CITY OF ALBUQUERQUE

May 30, 2022

**Re: Lot 3A-Block 2 @ Metz-Robertson Addn
109 60th St NW
Traffic Circulation Layout
Engineer's Stamp 05-23-2022 (K11-D093)**

C-106

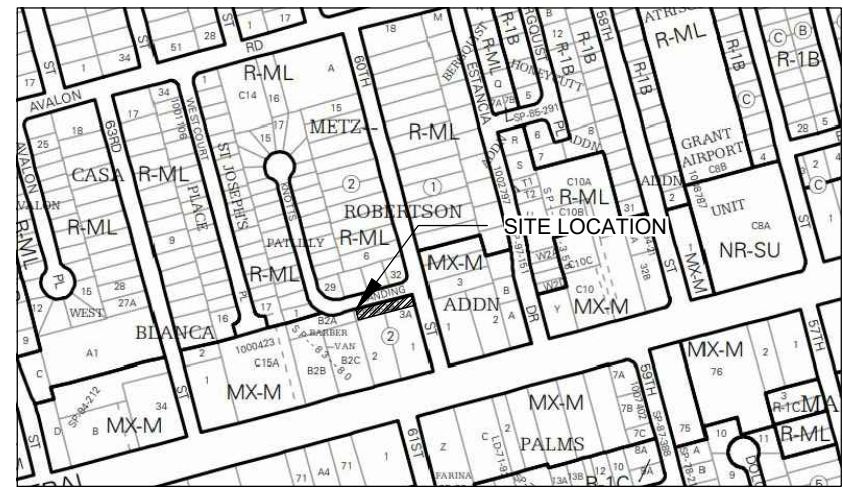
1. Knotts Landing & 60th St. NW- Infrastructure List & required items. below:

- **60th St.:** Include the proposed 5 ft sidewalk and its limits (begin and end limits).
- **24' F-F Knott Landing:** Include; entrance driveway (both driveways);begin and end limits (COA std dwg 2426: includes 6 ft valley gutter, curb returns and ADA ramp).
- **22' E-E Knotts Landing Temp.:** Include 22' concrete driveway; surfaces (20' ac & 6" base coarse); add limits.
- **22'E-E Knotts Landing temporary Infrastructure:** Include 22 ft- driveway/pad, 20 ft of Asphalt, +103 ft of Base Course; add limits.
- Provide a copy of the infrastructure list and items mentioned above for review/coordination (Per City Engineer discussion).

2. A Condition of Final C.O. (60th Street Frontage):

- Proposed sidewalk will need a Sidewalk Easement.
- You will need adjacent property owner to provide a letter of concurrence for proposed sidewalk on his frontage.
- Final C.O. Condition of approval will be required for the two items stated above.
- **The items above will be required prior to an issuance of TCL approval except C.O. condition.**

3. Legend: The legend symbol for concrete shows 4" but driveway entrance per COA std dwg 2425 calls out 6". Please adjust Legend text for concrete.

4. Proposed ADA Ramp around parameter of Existing Portable:

- **Hand railing:** Include handrailing details per (ADA Standards for Accessible Design Manual); add taper run, landing, edging, height, etc..
